City of Portland, Maine - Building or Use Permit

Proposed Use: Six (6) Family Residential Combine 3rd floor egress with 1st & 2nd floor egress and remove existing fire escape	Proposed Project Description: Combine 3rd floor egress with 1st & 2nd floor egress and remove existing fire escape
--	---

**PUBLIC HEARING
170-172 CLARK STREET**

Application For: Certificate of Appropriateness – Modifications to Rear Egress

REAR VIEW
FRAMING DETAIL

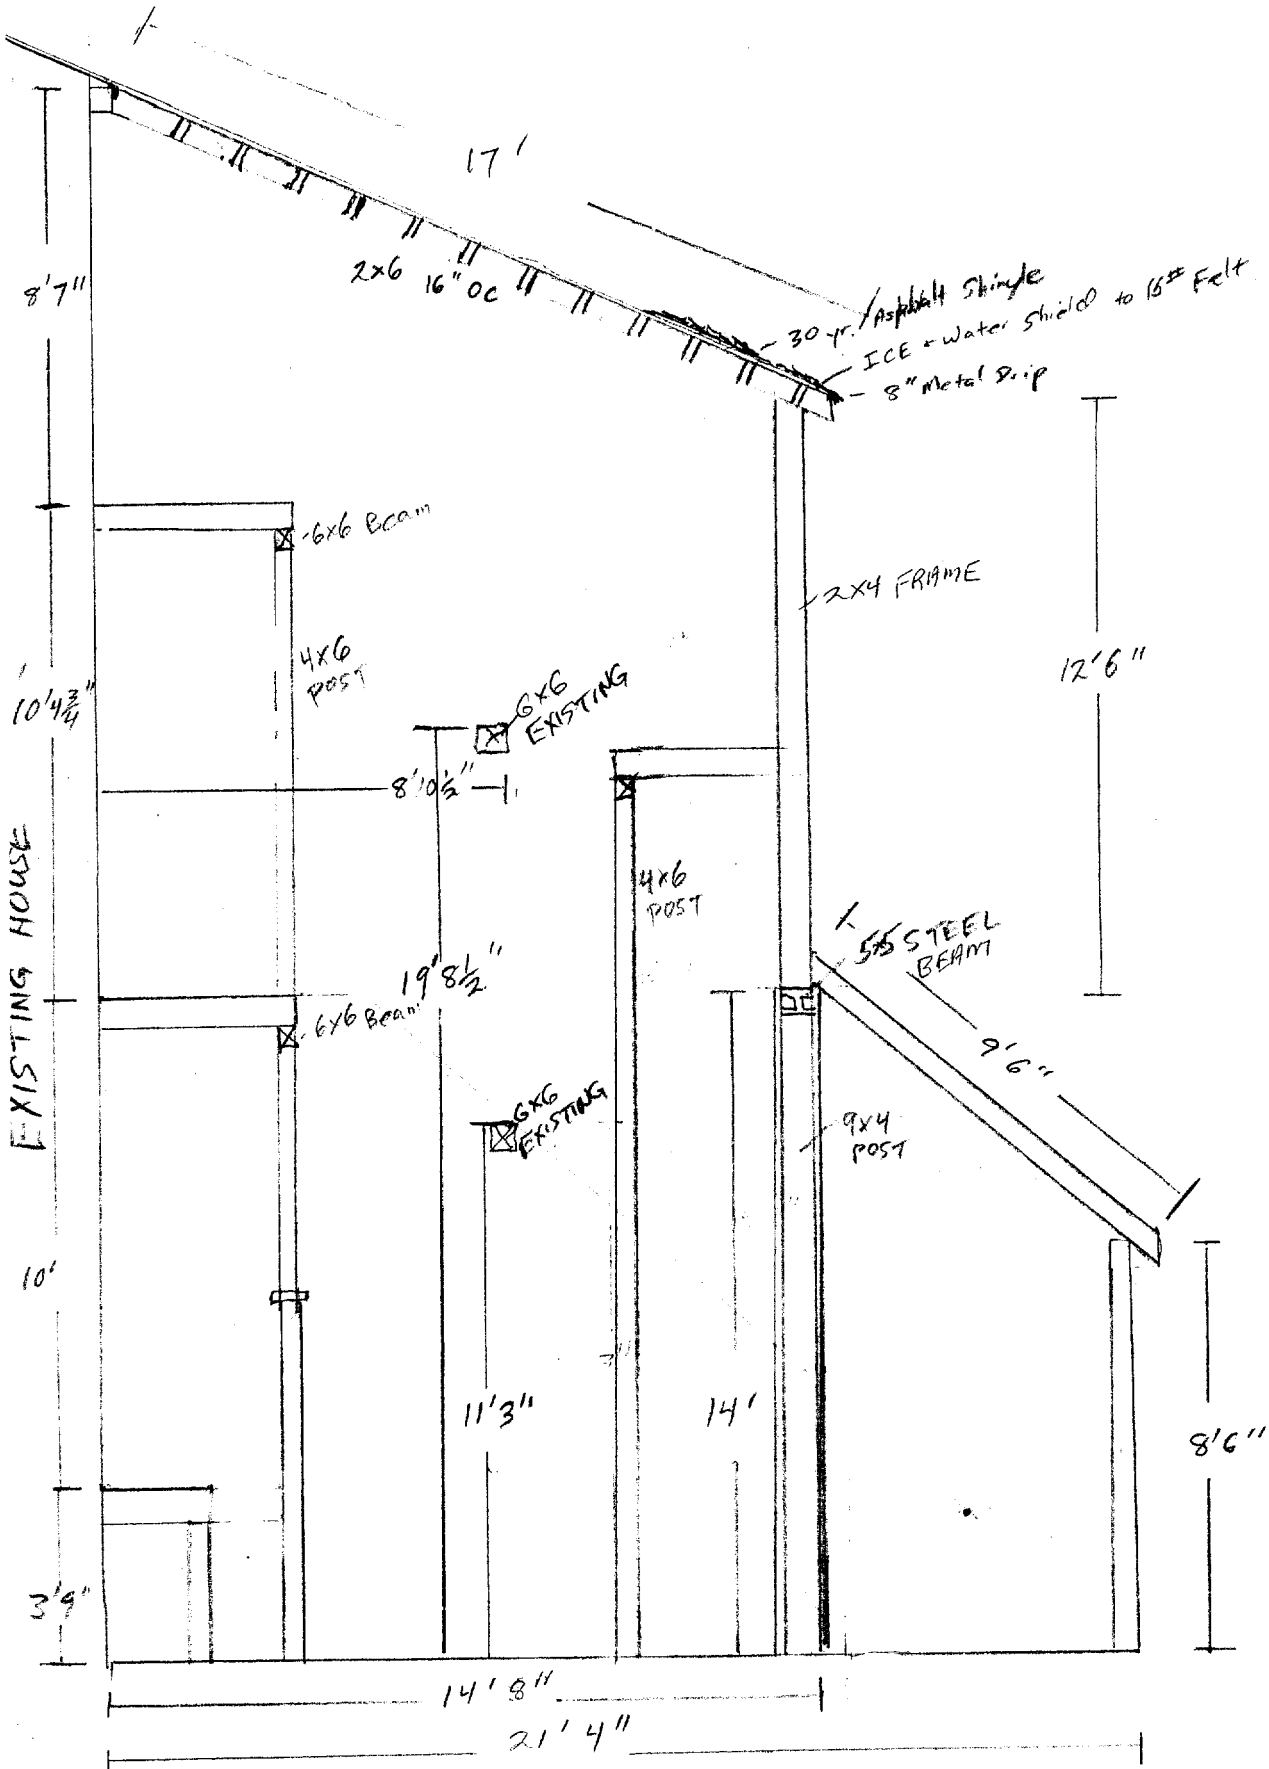
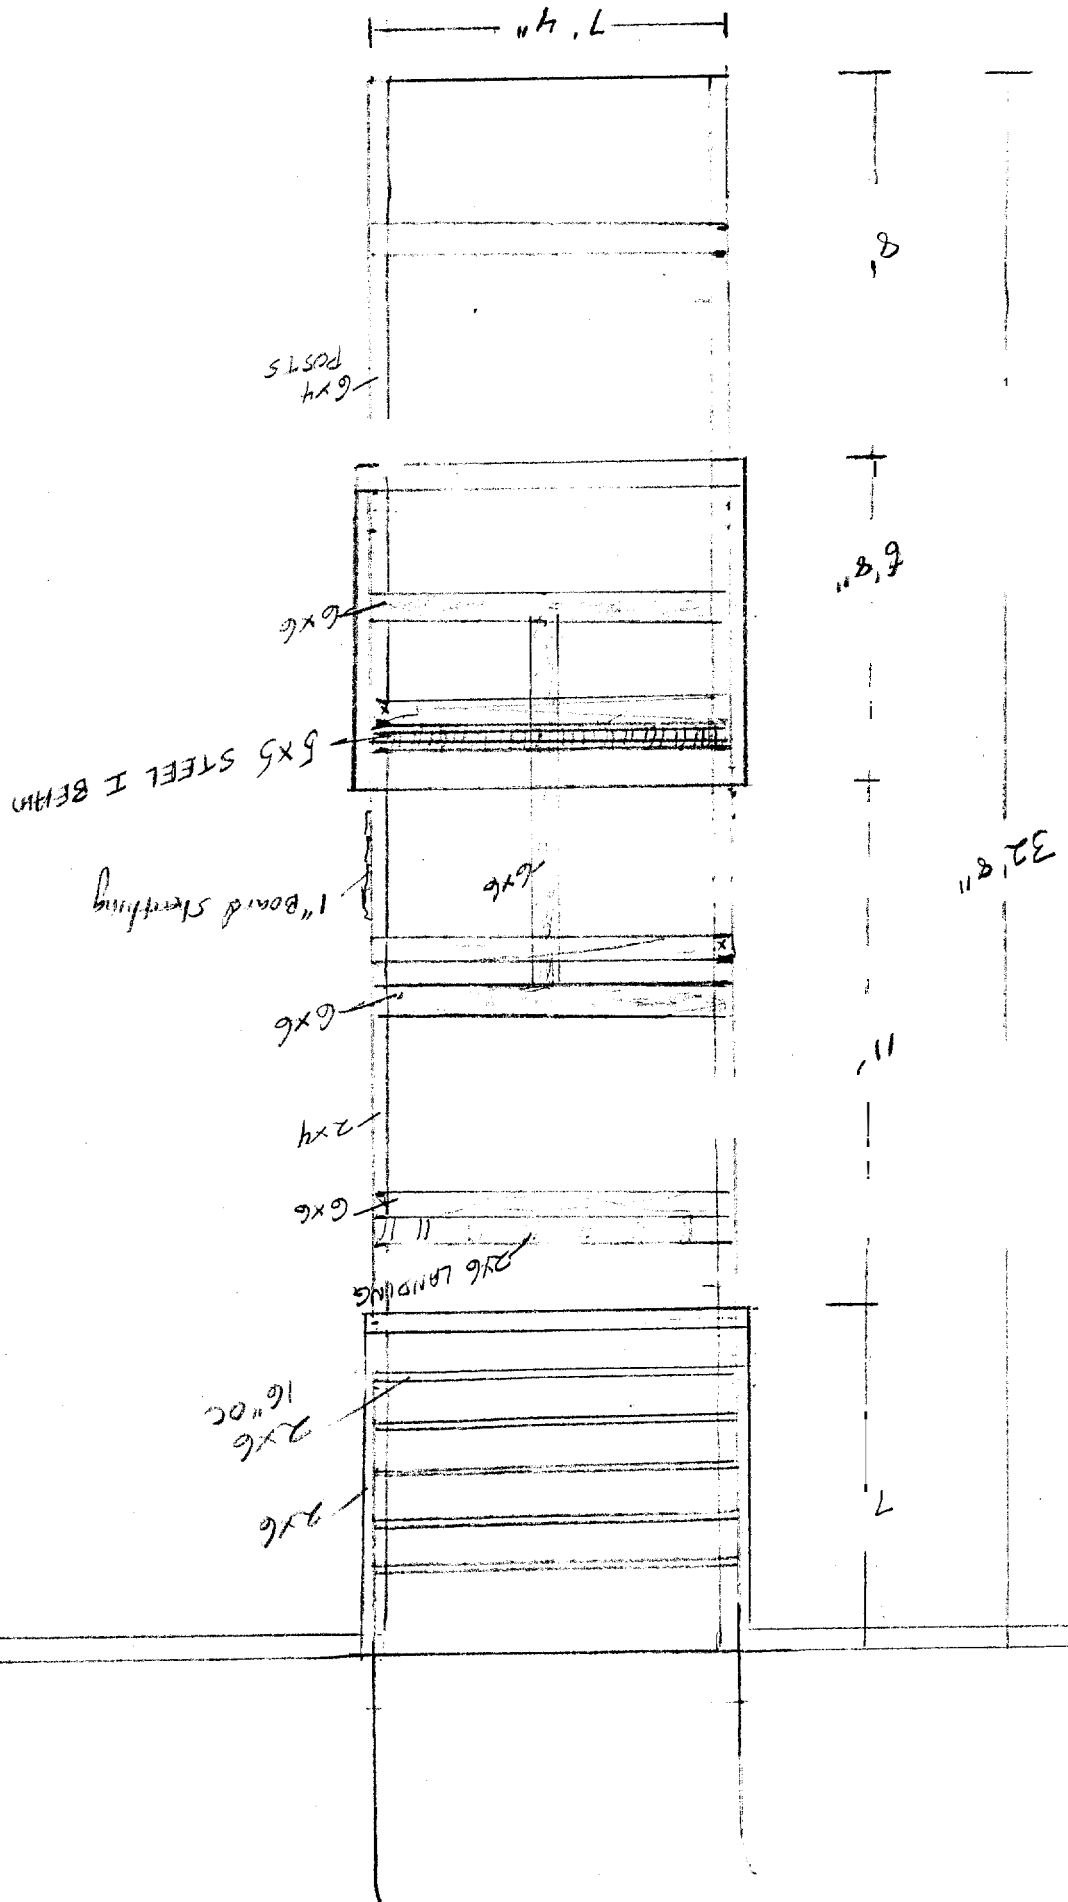
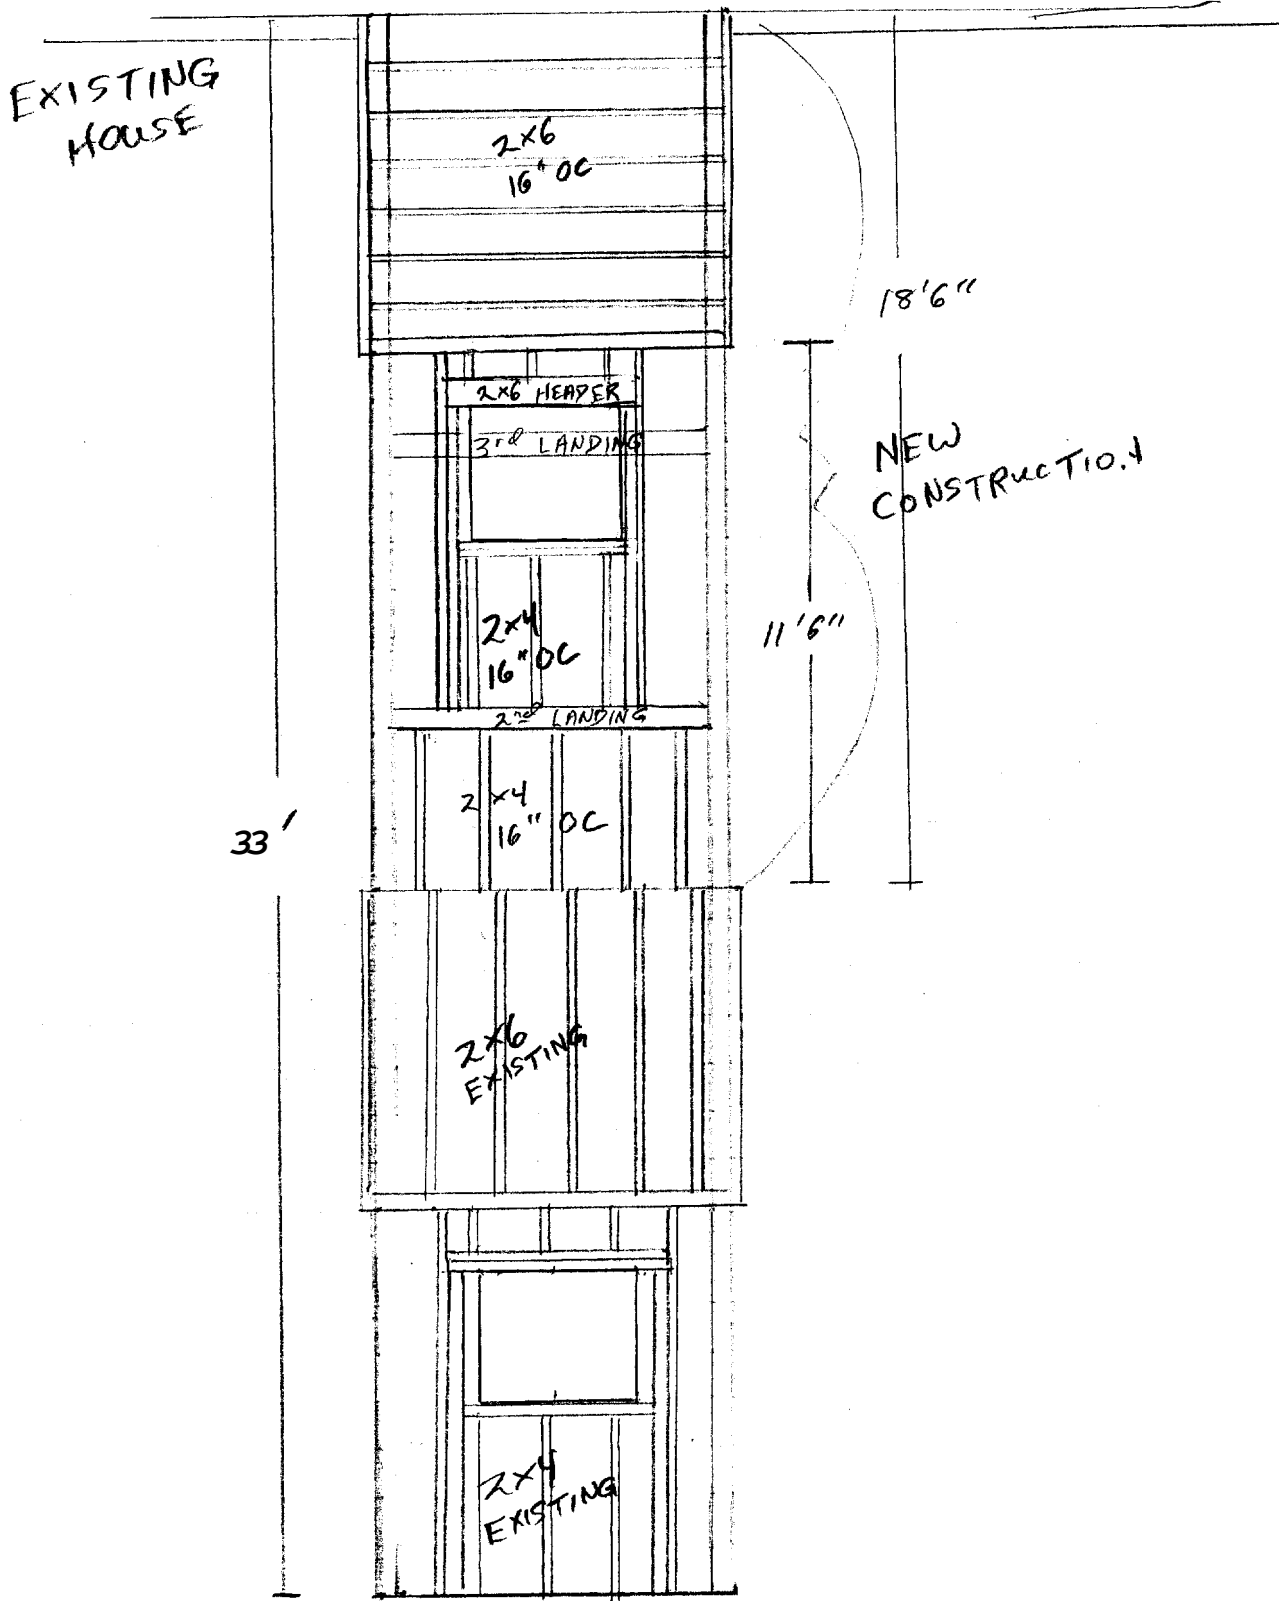
Given the limited nature of the documentation provided, the Board will need clarification on a number of construction and architectural details, including more information as to how the addition will tie into the existing dormer's roof, confirmation of roof pitch, etc.
